Project Name: Bampton Estate
Document Date: 24.11.2023
Document No: 92-BMT-SBA-00-ZZ-CL-A
Document Name: Hard Landscape, Planning Condition 15 – Hard Landscape Material, Asphalt
Prepared By: Jeremy Randall (GML) 12.01.2024

Bampton Estate, Lewisham // Application to discharge condition 15, Hard Landscape

We hereby seek to discharge Condition 15 – Hard Landscape Phase 2 attached to Planning Consent DC/19/112918 amended under DC/21/123804.

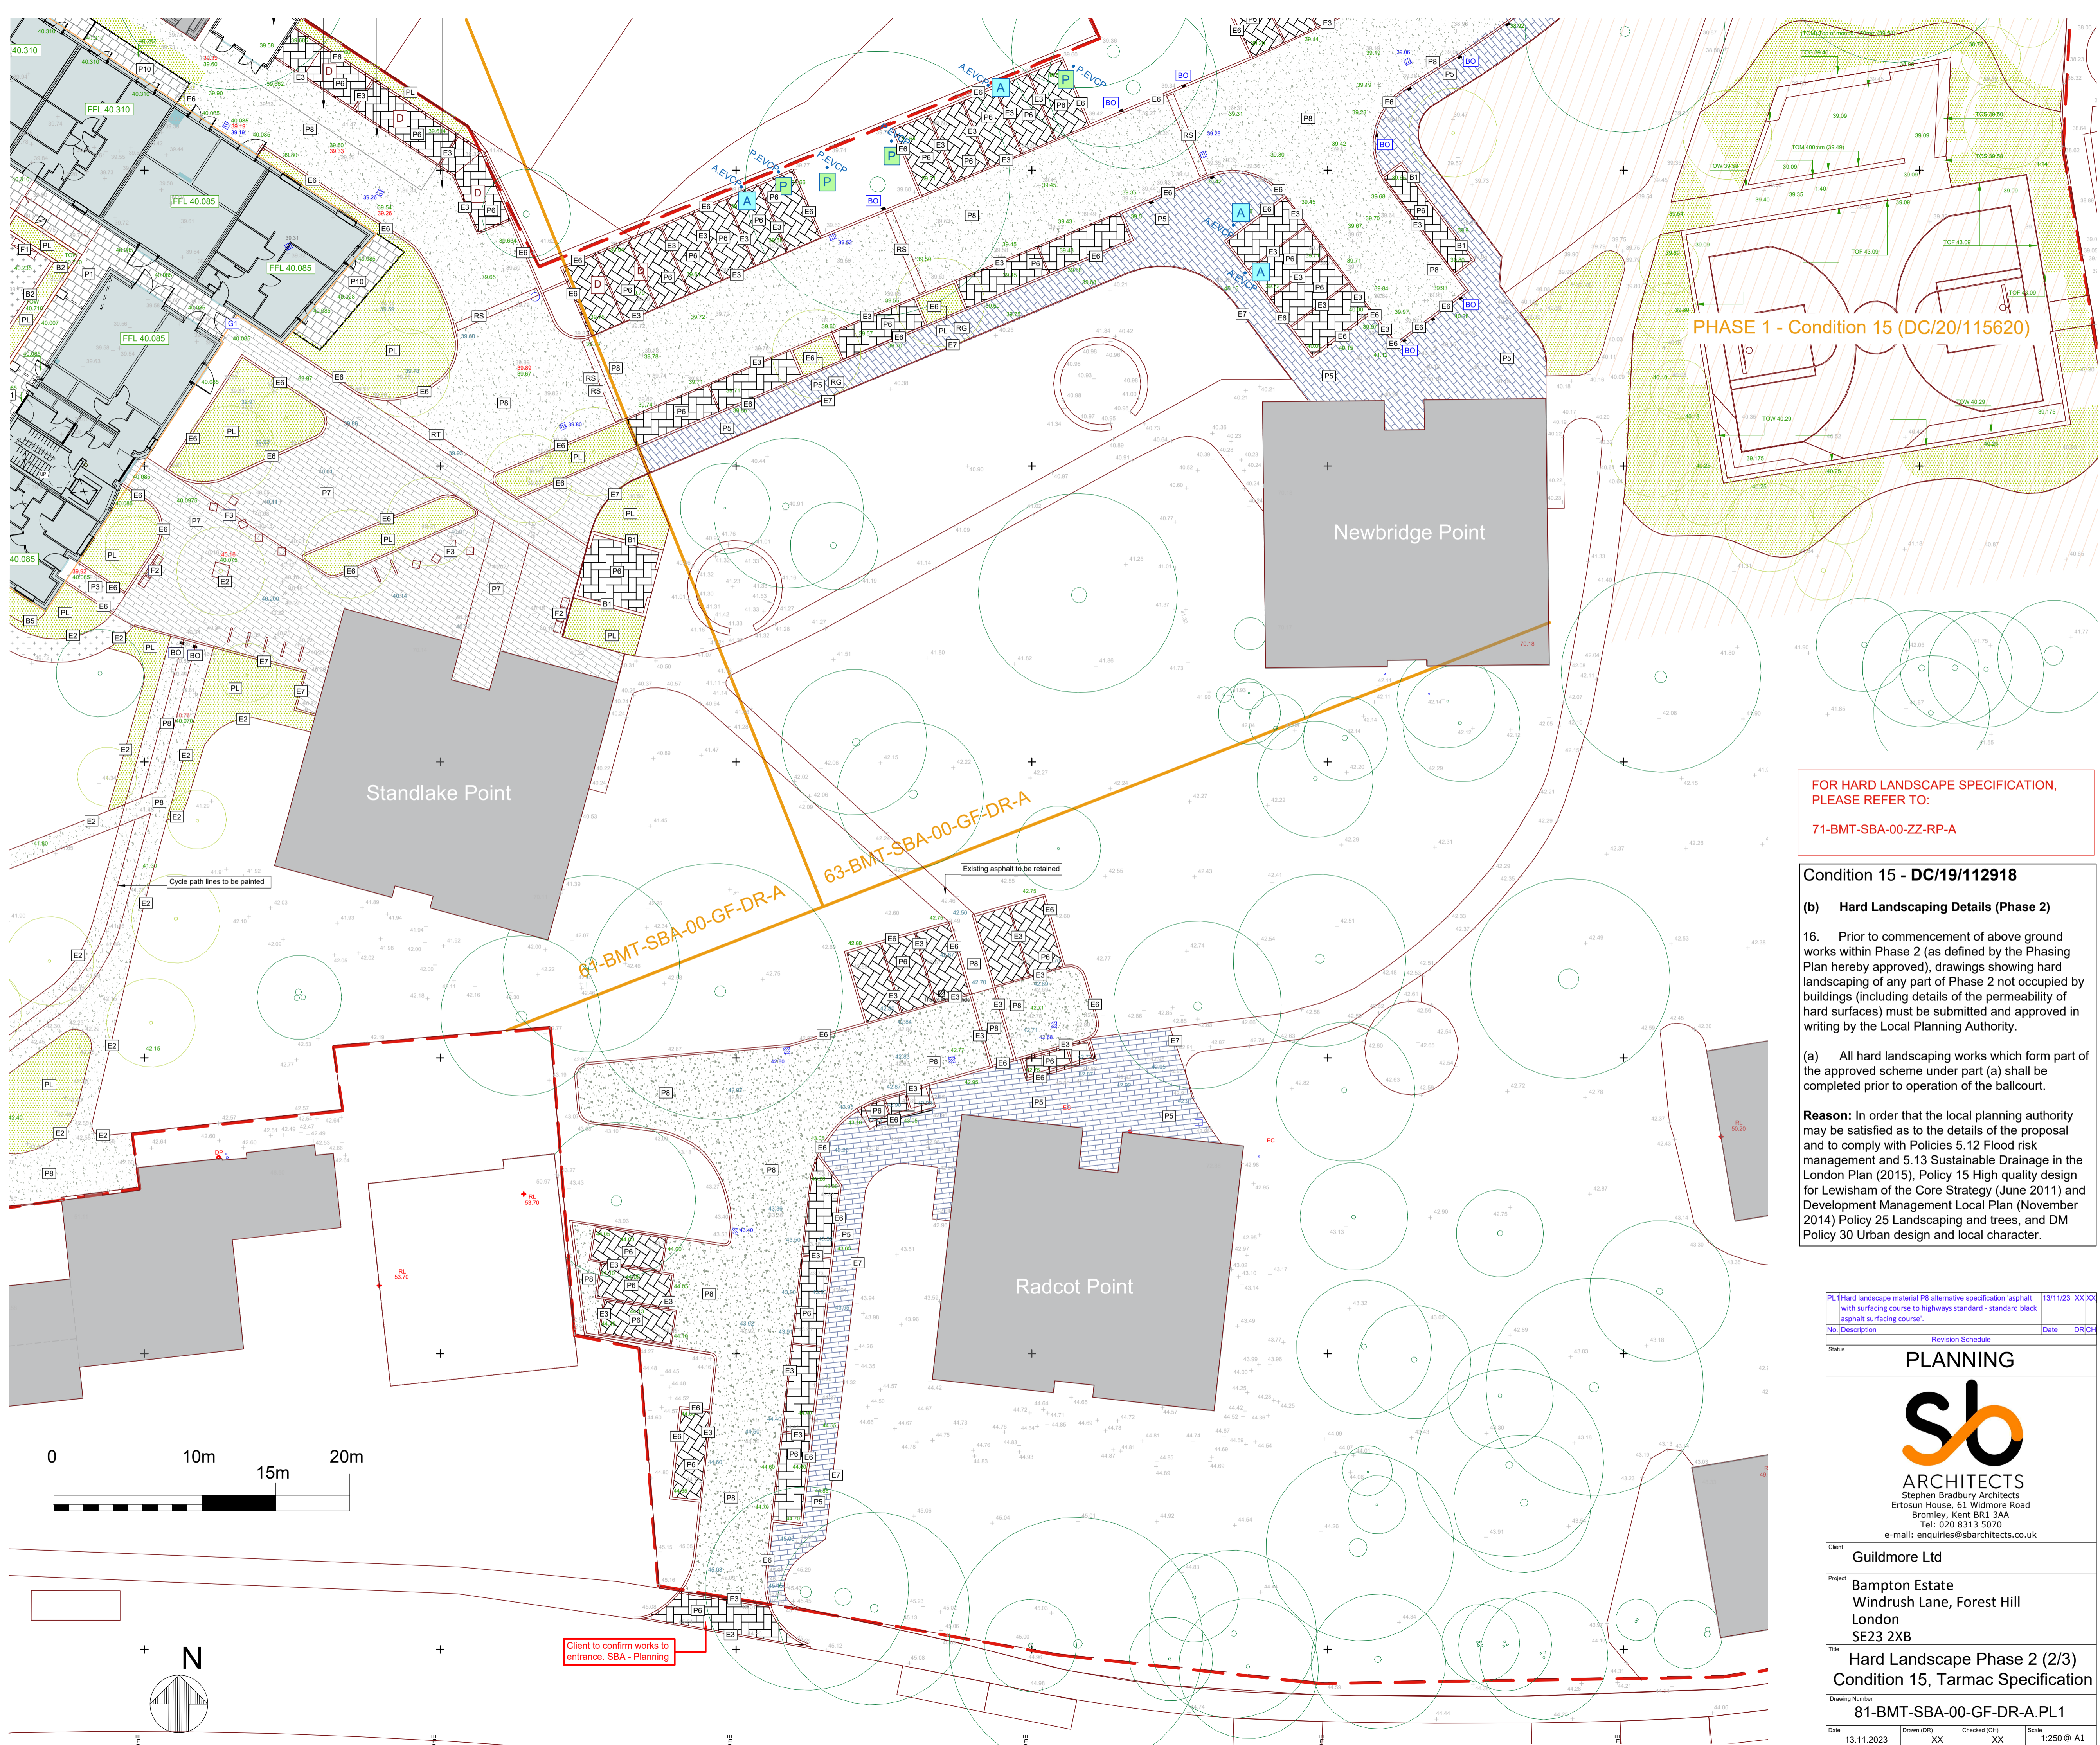
We are applying to have an alternative material specification approved for landscape material P8 which is the road and path wearing surface.

Have a specification for P8 as

ASPHALT WITH SURFACING COURSE TO HIGHWAYS STANDARD - NATRATX COTSWOLD SURFACING COURSE
---	--

We are requesting that the alternative material specification as shown on the submitted drawing be approved.

The reason for the requested change is the current specification of the buff Cotswold colour as road and path wearing surface will discolour and stain. It will be very expensive for the London Borough of Lewisham to maintain, patch and replace in the long term. The currently approved material is 4 times the cost of standard highways approved black asphalt and therefore will be an ongoing maintenance cost issue.

ASPHALT WITH SURFACING COURSE TO HIGHWAYS STANDARD - STANDARD BLACK ASPHALT AC10 CLOSE GRADED SURFACE COURSE
---	--
